Weir Phillips Heritage

20 September, 2017

**Re: State Significant Development Application for the Redevelopment of UNSW
Cliffbrook Campus (SSF 8126)**

title  
**General Arrangement Plans**  
**Heritage Refurbishment**

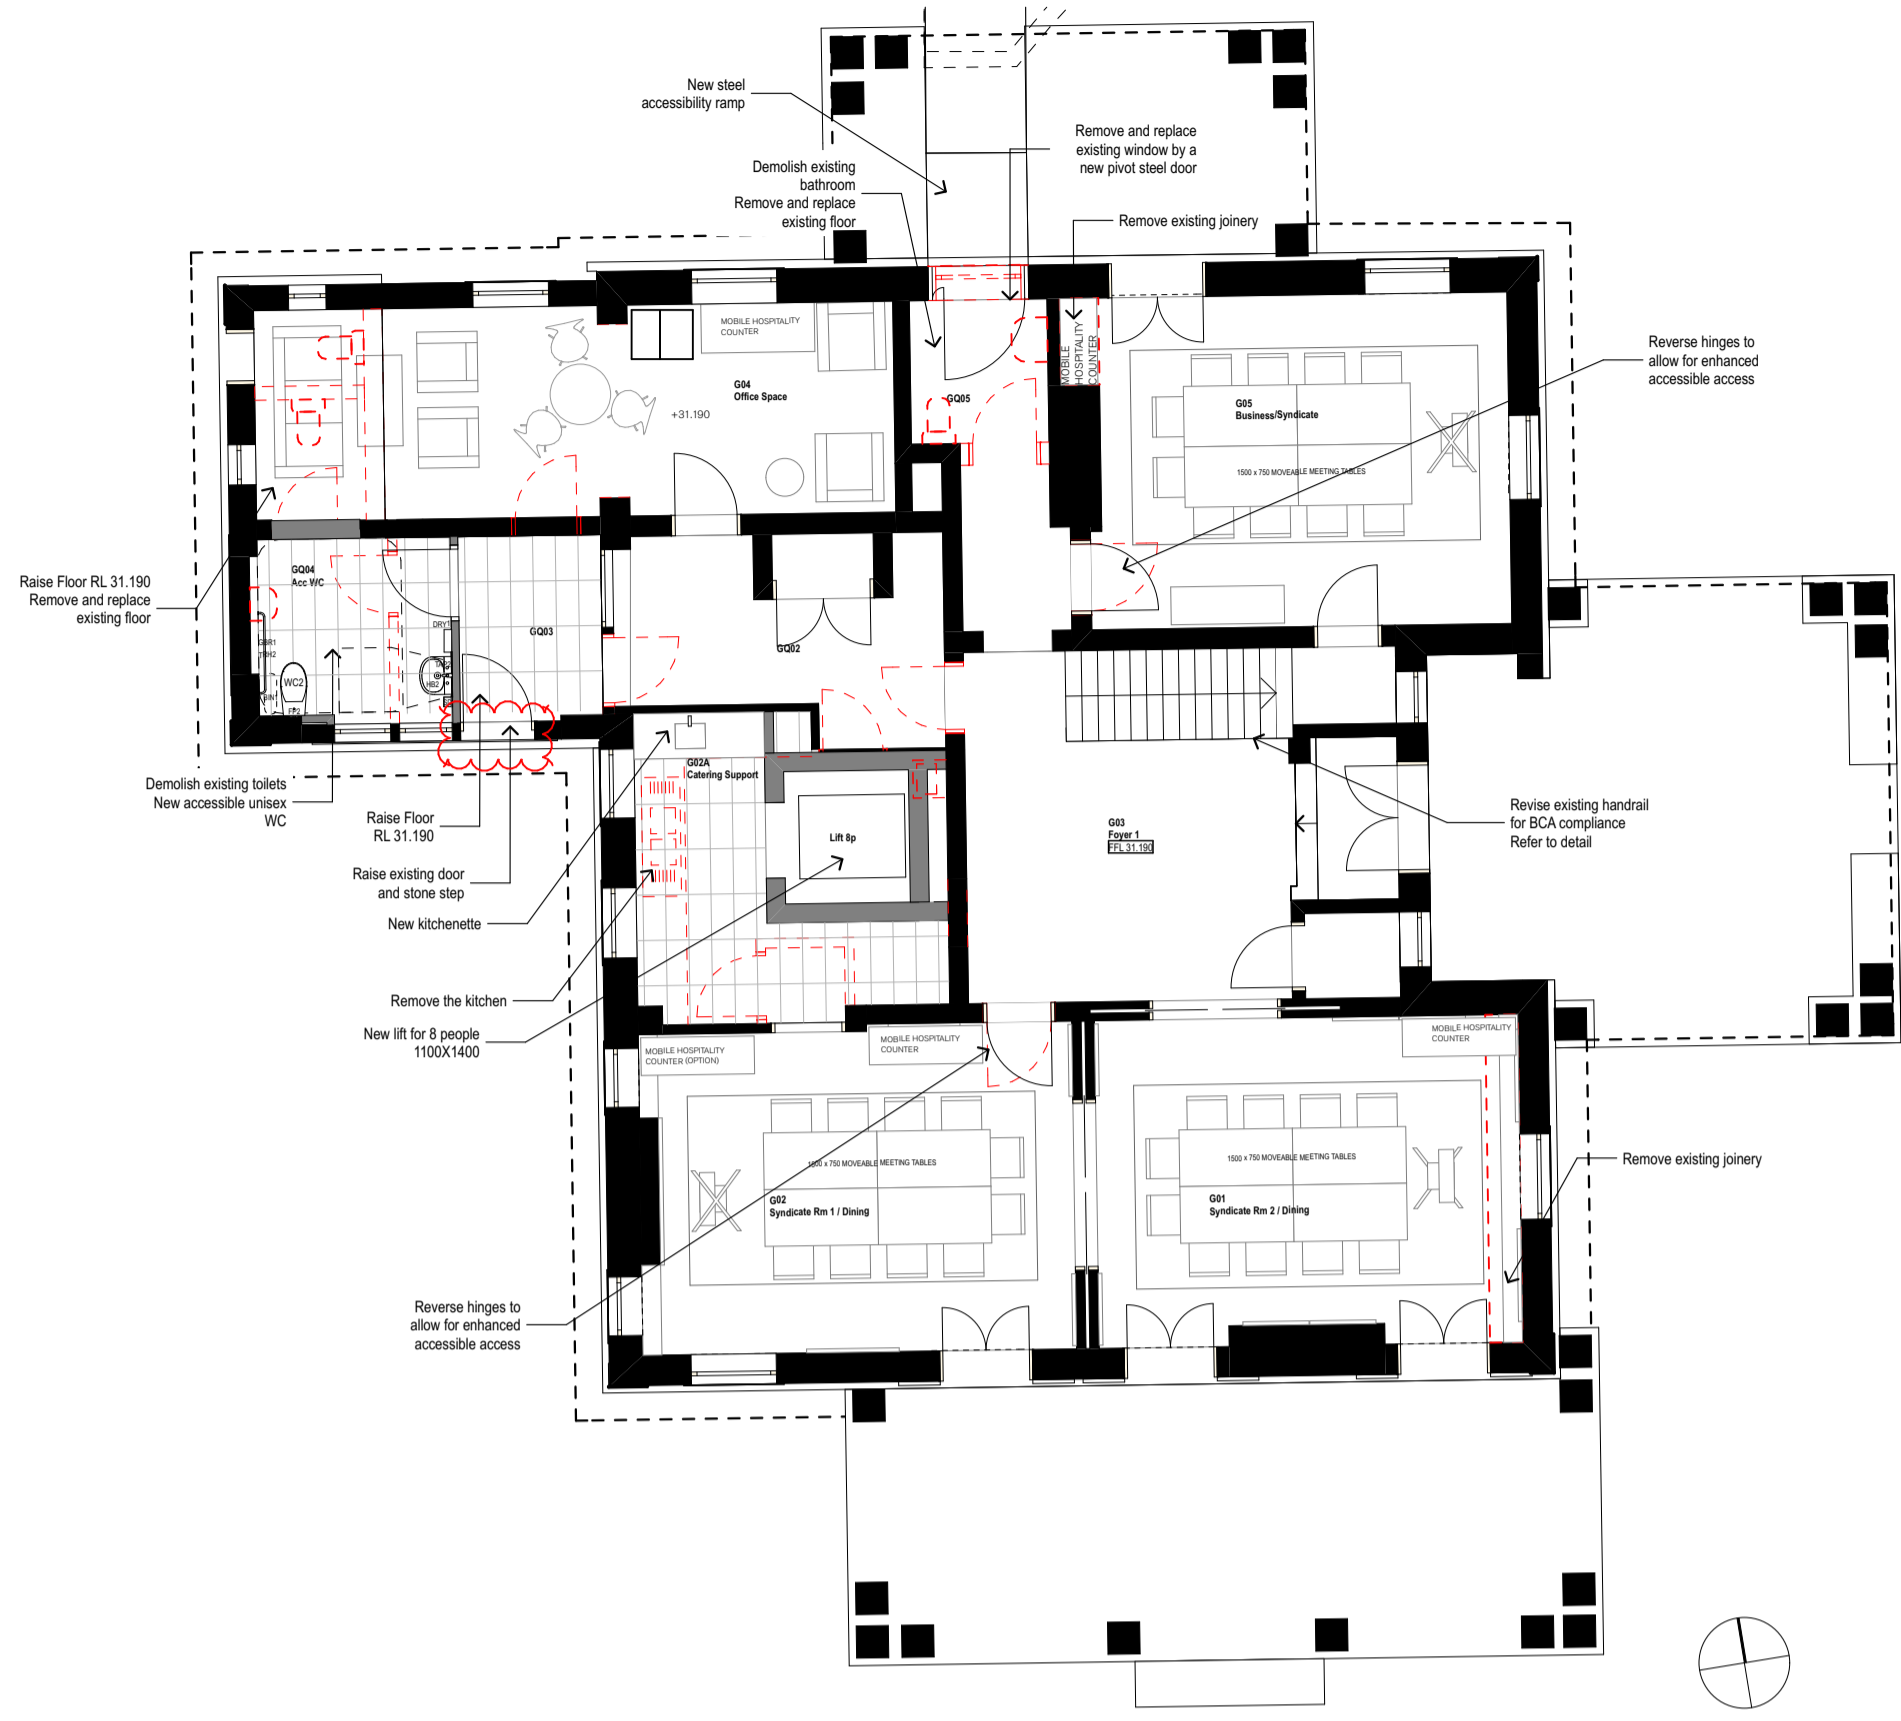
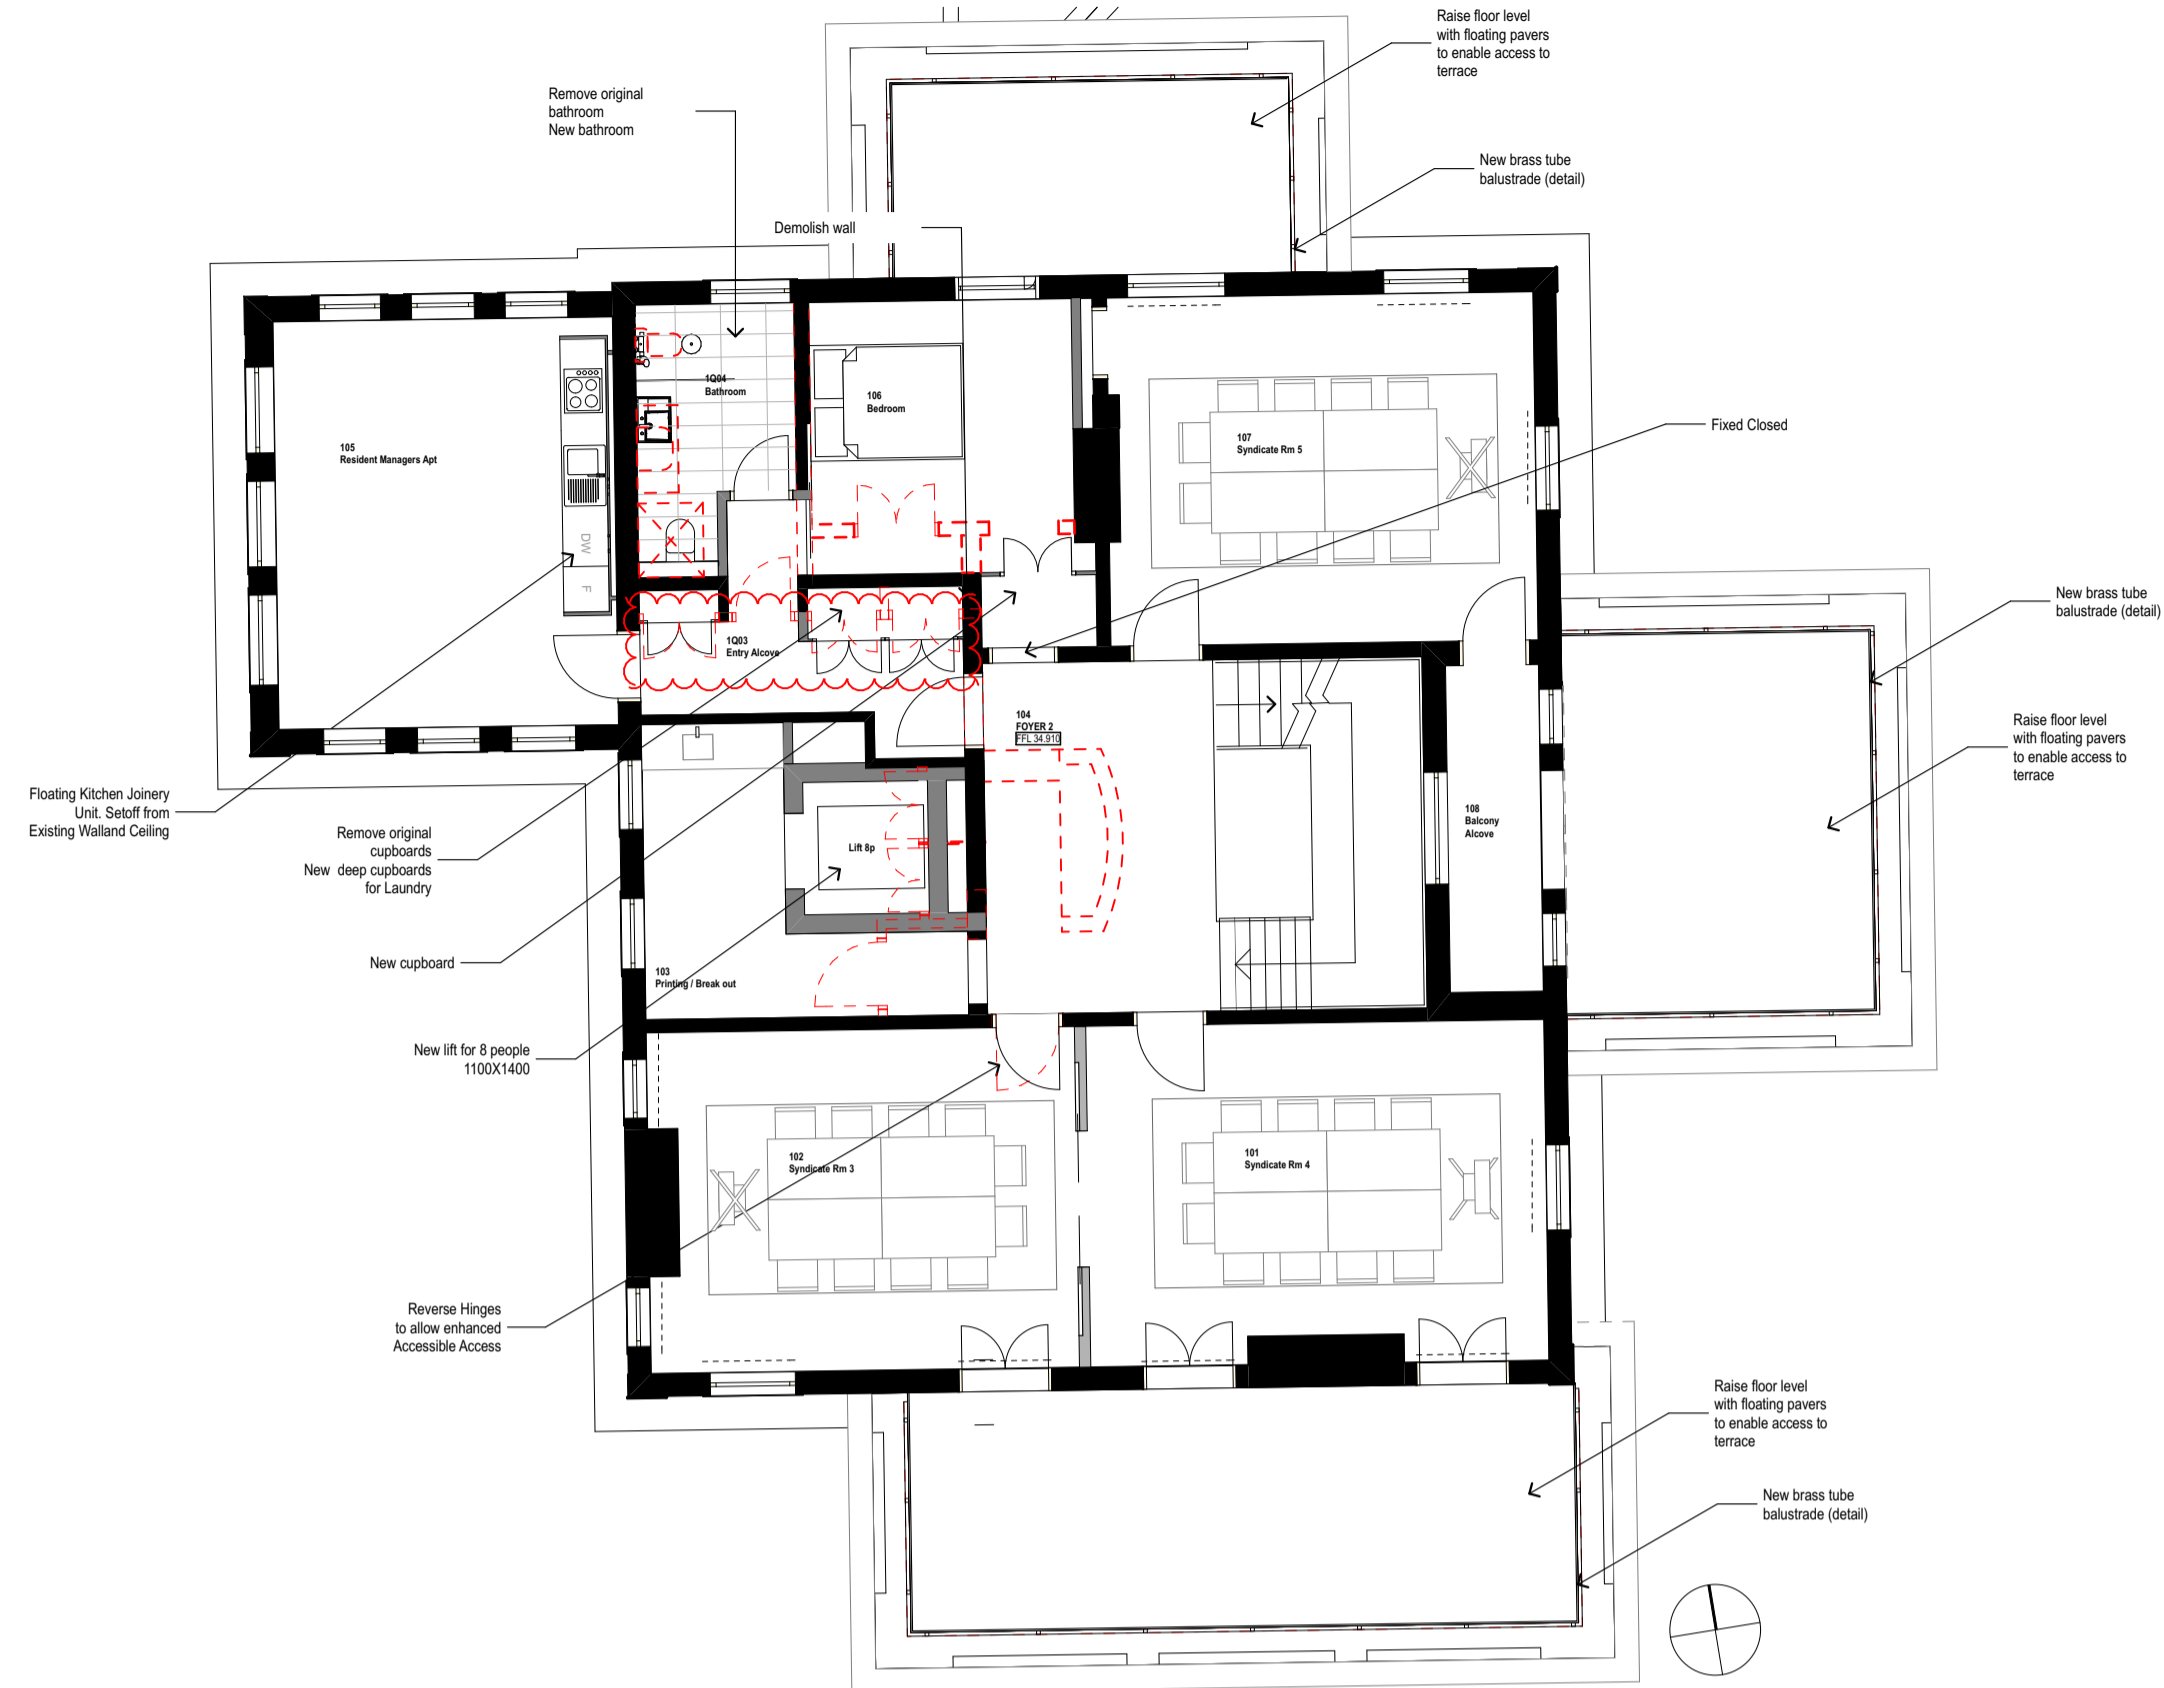
Change	Impact
Raise floor in area where floor lower to make access to the toilet (ground floor)	This work is required to make the space accessible. The floor currently steps down from the adjoining room. The impact is acceptable. This area has been altered by past works and is a secondary, utility, space. Raising the floor will not result in the loss of a significant floor surface. The threshold into the adjoining room should be salvaged.
Raise door and add external step outside to align with new floor levels (ground floor)	The impact is minimal and acceptable. This space was originally an open porch; the door is not original or significant fabric. This is a secondary elevation; the addition of an exterior step will have a minimal impact. The terrazzo door threshold can be re-used.
Remove cupboards and add a laundry to the Manager's apartment (first floor)	This work will have no impact. This cupboard is not original or significant fabric and does not provide information about past use not available in other records.

Remove the surviving original fixtures and fittings in the Level 1 bathroom	While remodelling was shown in the original application, it was not clear if the surviving terrazzo floor and wall tiles would be retained. It is now proposed to remove these finishes. The impact is acceptable because the finishes are in poor condition and because not enough of the original fabric/fittings survive to truly appreciate the character of the original space.

2 PLAN Ground Floor - Garage 1:100

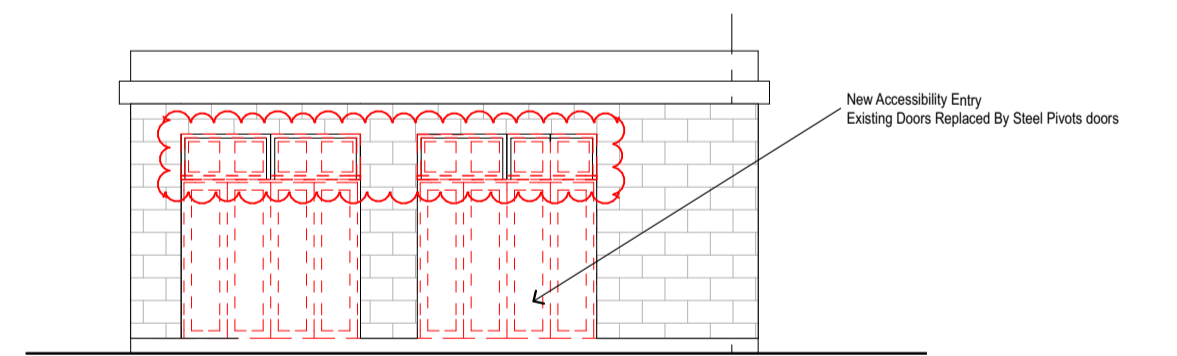
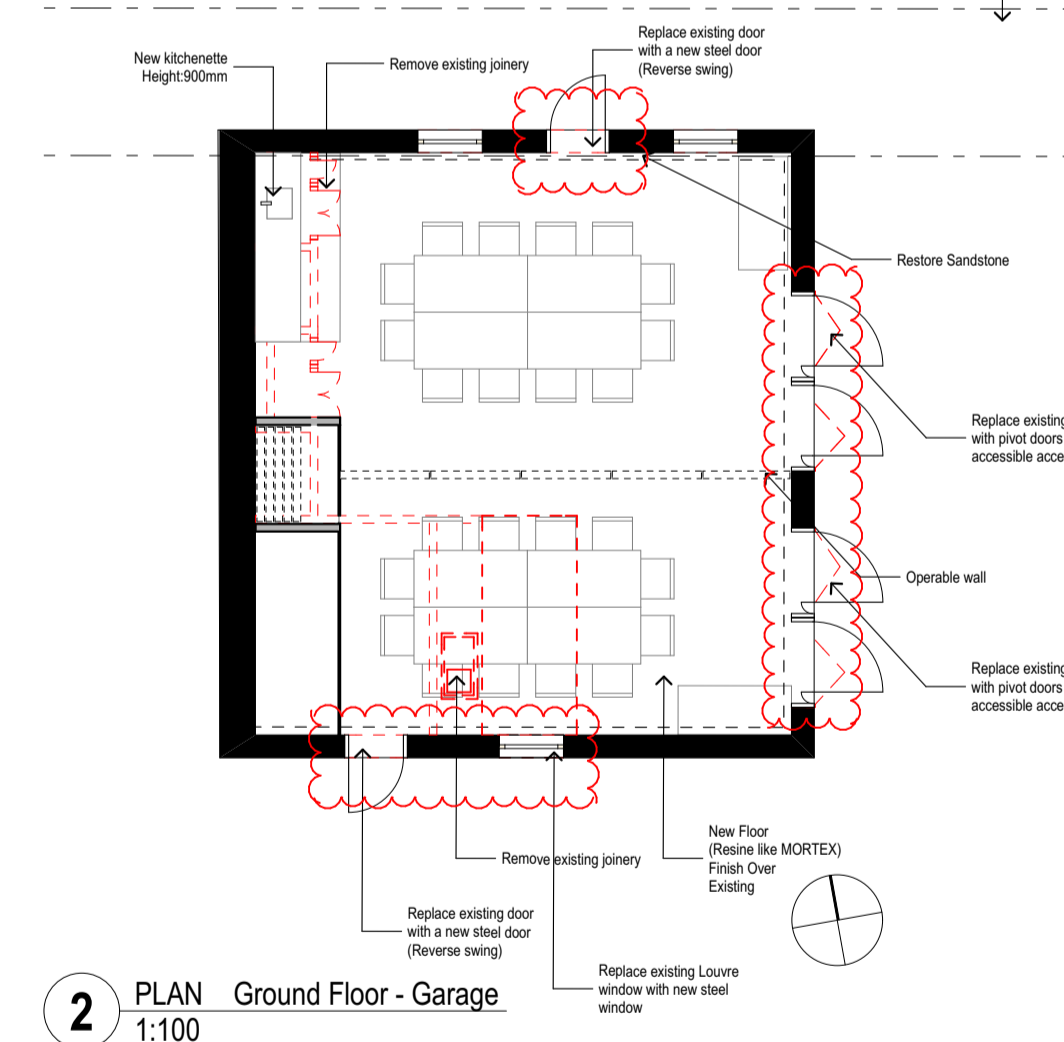
Change	Impact
Remove highlight windows above the entry doors and extend height of new doors	This work will have no impact. These doors are not original or significant fabric, but were installed in 1993. No changes will be made to the openings. The glazing pattern does not follow a known earlier pattern.

Change	Impact
Replace 2 x side doors north and south with new doors and reverse swing.	This work will have a minimal impact. The doors are not original or significant fabric. Their replacement will have a minimal impact. The openings will not be modified.
Replace south side louvre window with new window.	This work will have a minimal impact. This window has been previously modified. The opening will not be altered.
